# Project Submittal Interim Form

More Info Received

**Project Name: \*** Bridge No. 82 over Burnt Coat Creek on NC 11/111 in Duplin County (B-5534)

B-5534

PROJECT REFERENCE NO.	SHEET NO.
B-5534	EC-4/CONST.4

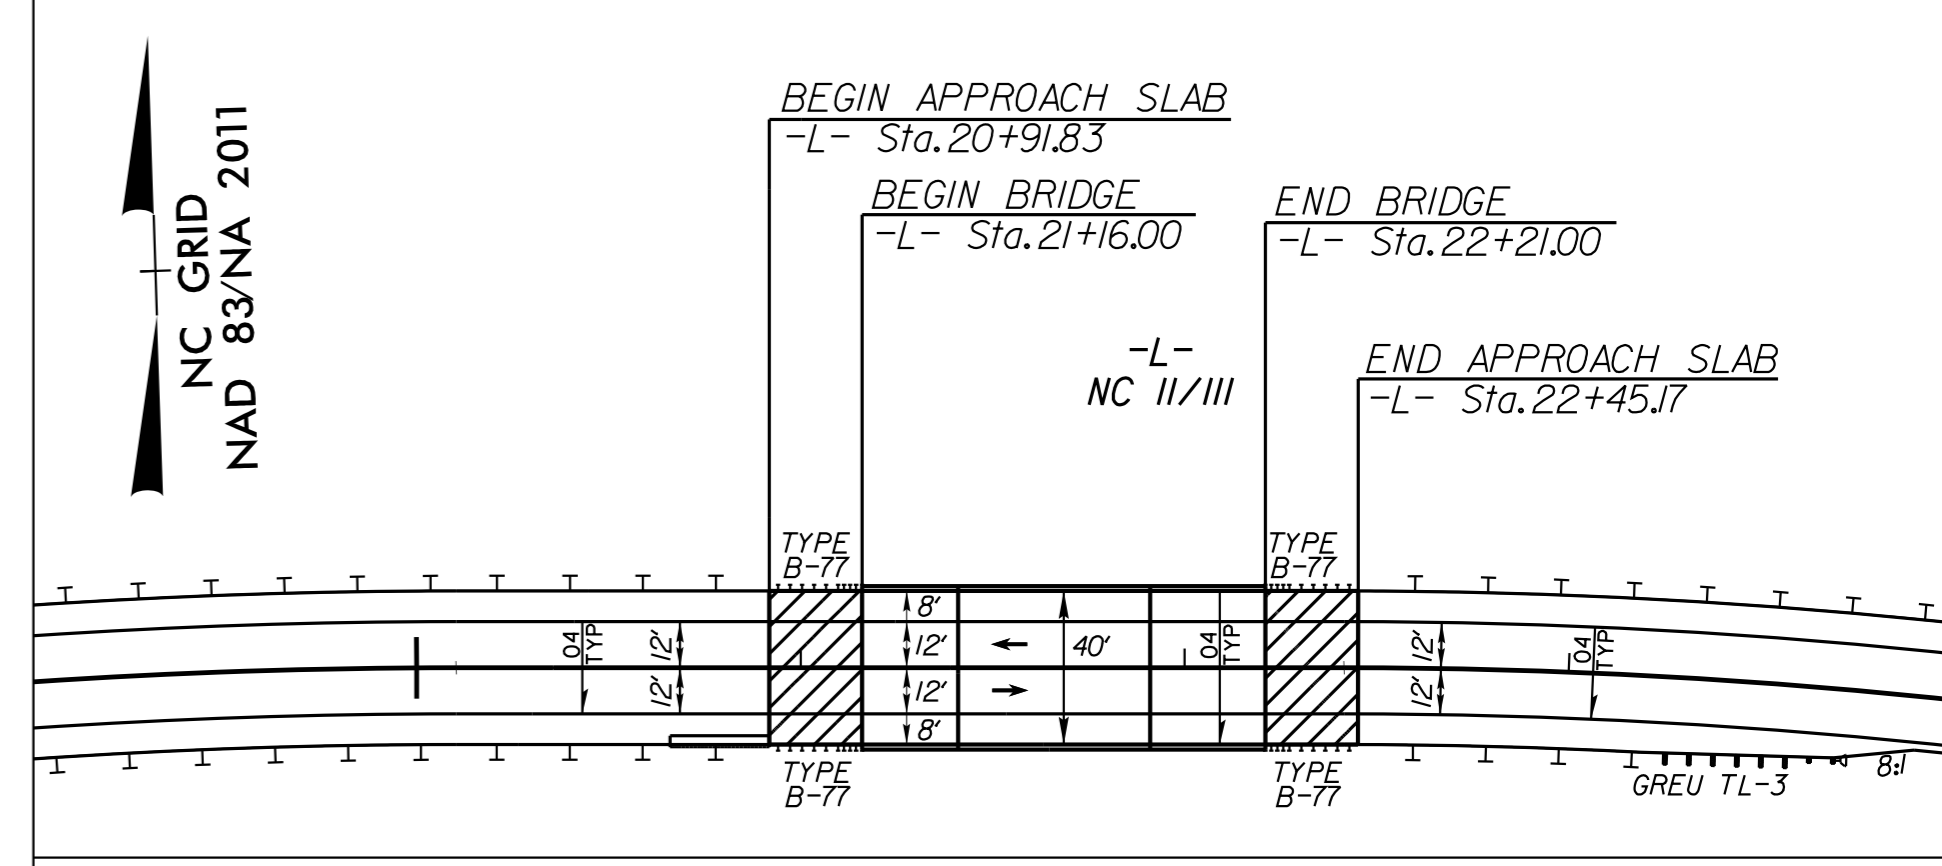
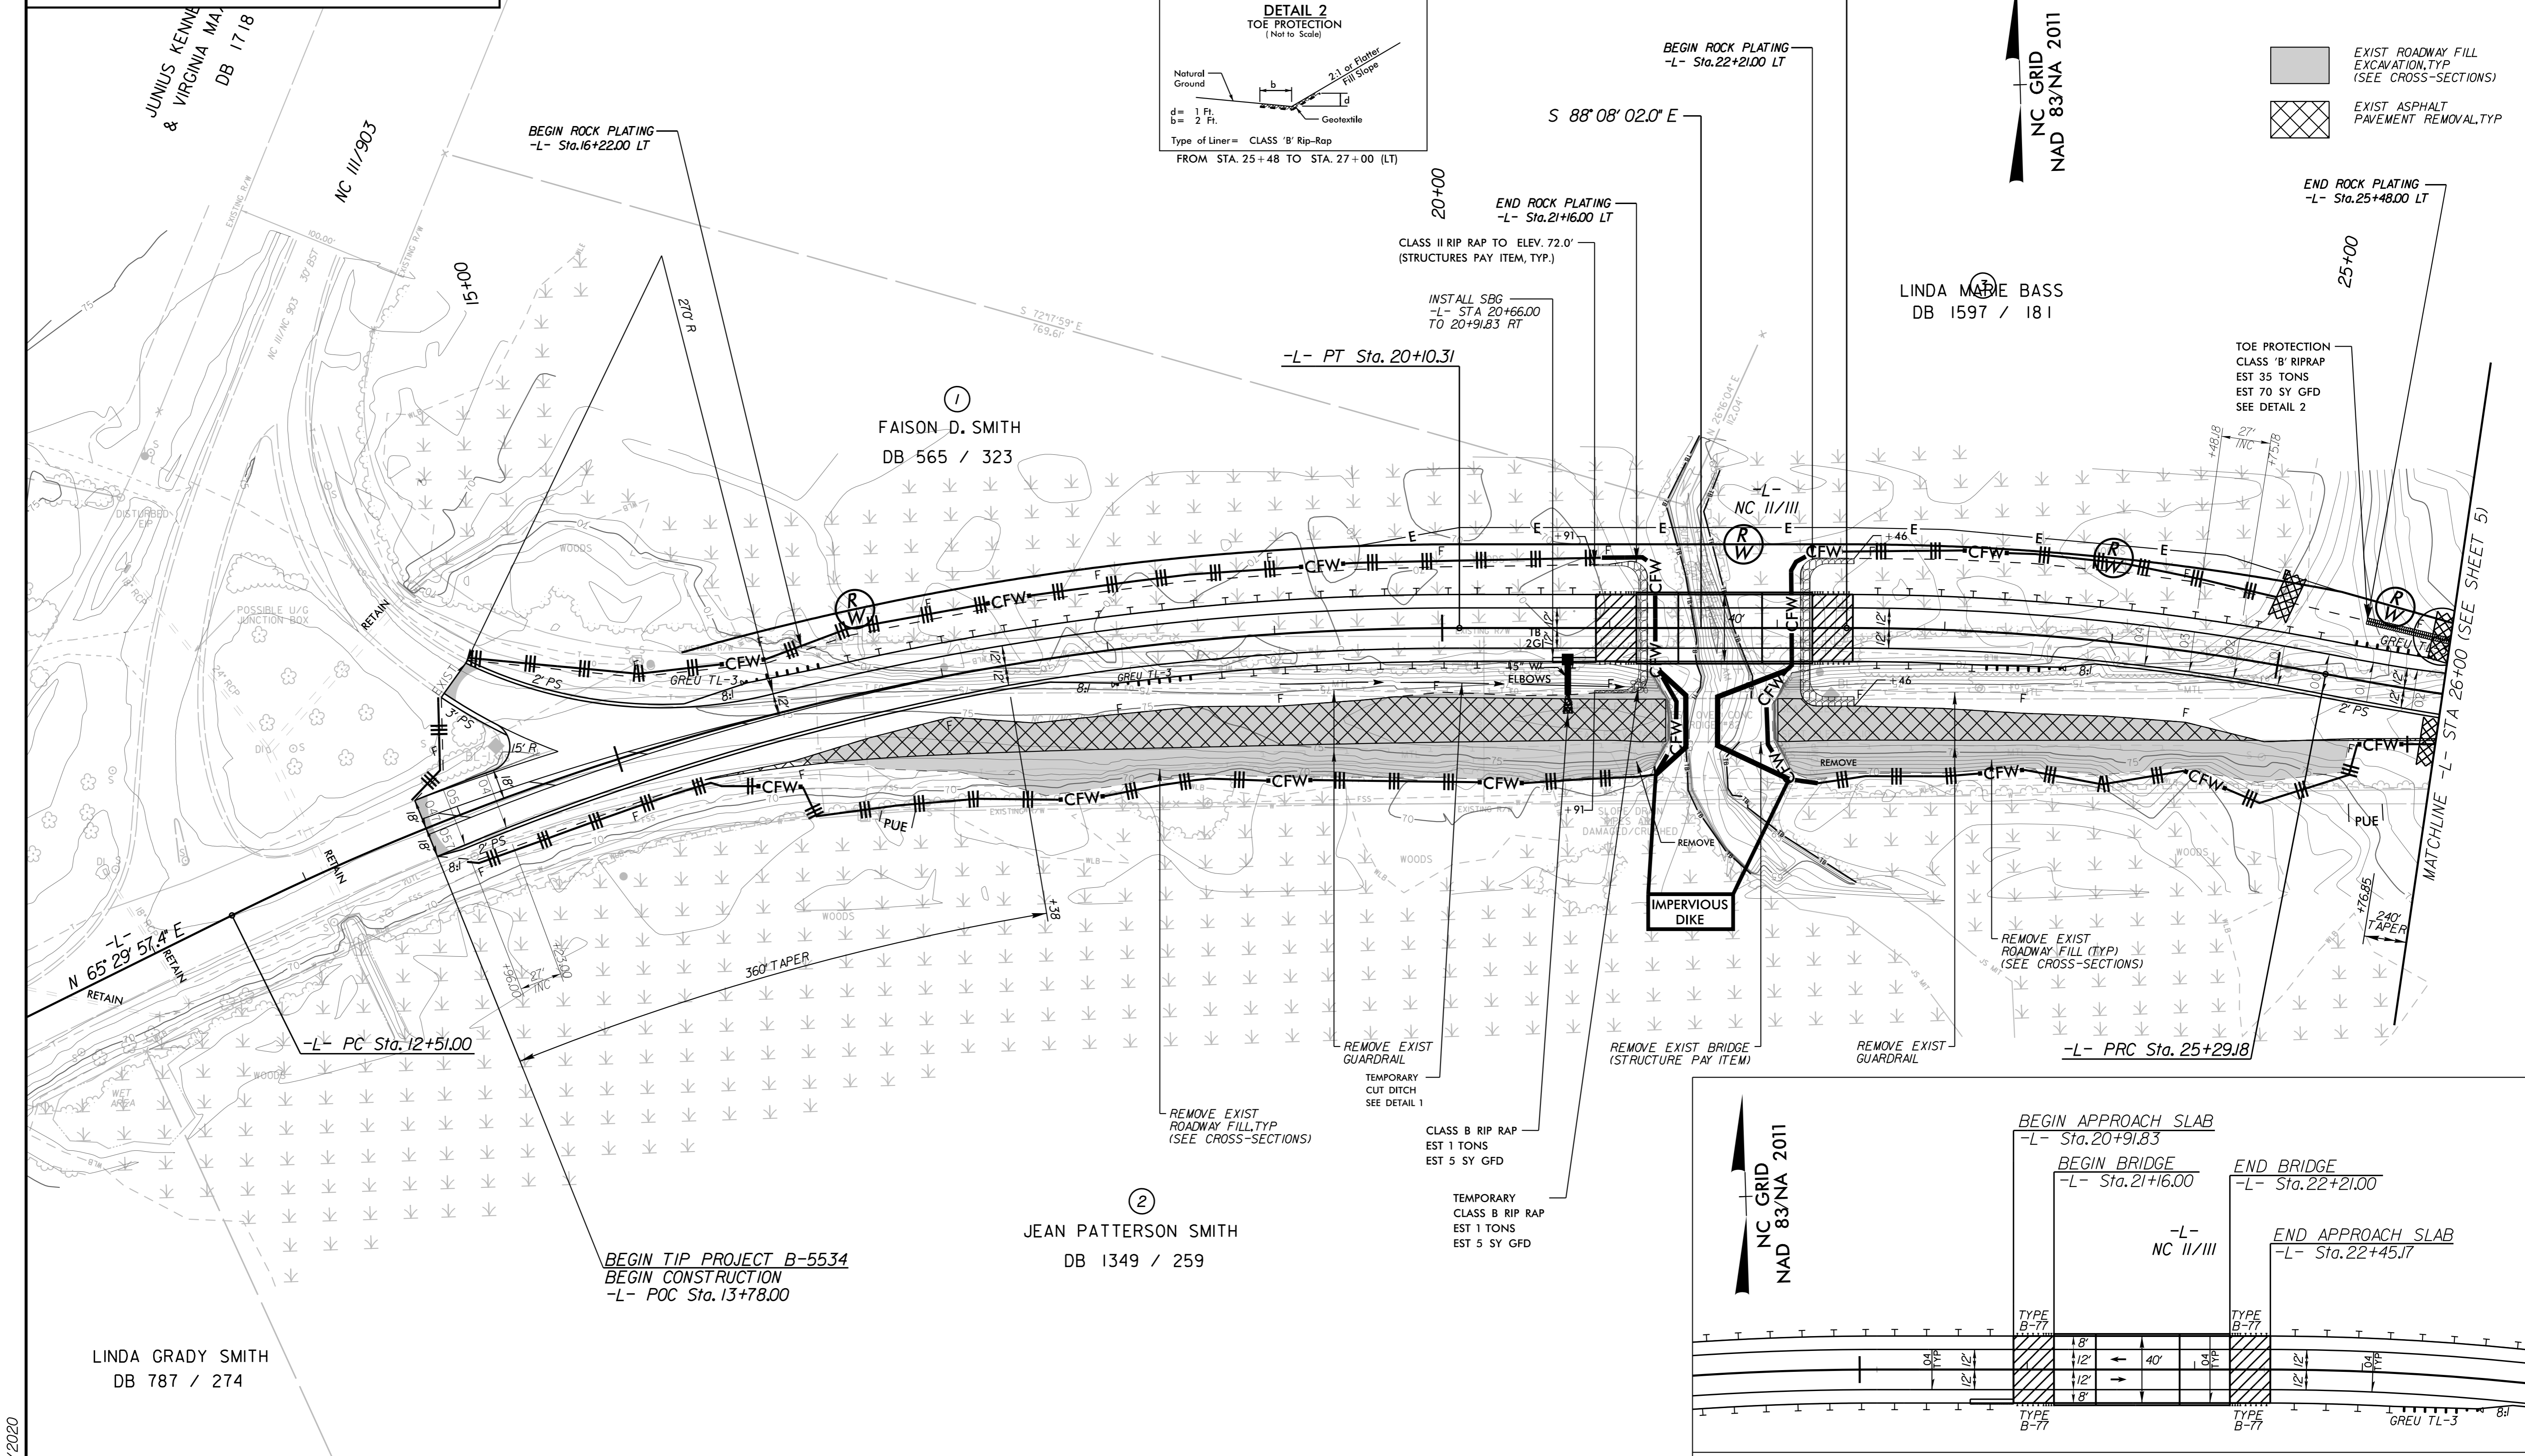
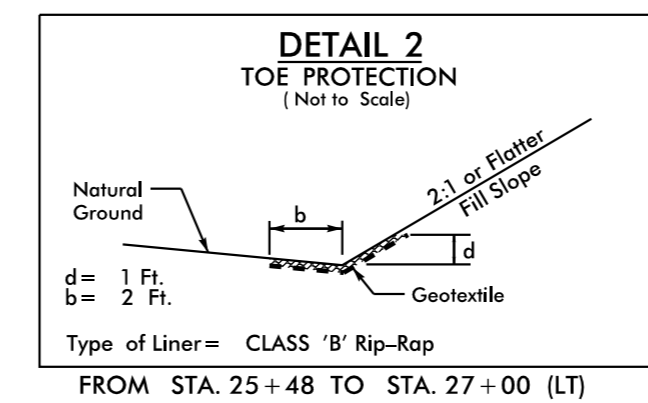
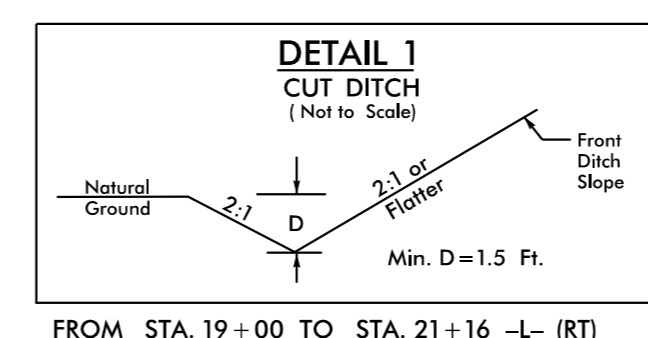
Impervious dikes have been added around the existing bridge.

The previous version of the drawings incorrectly included 0.02 ac and 69 lf in the summary table. This should have shown 0 for both. Now that the impervious dike is added as a temporary impact, the plan sheets show it as such, and the table has been updated to 0.02 ac and 52 lf.
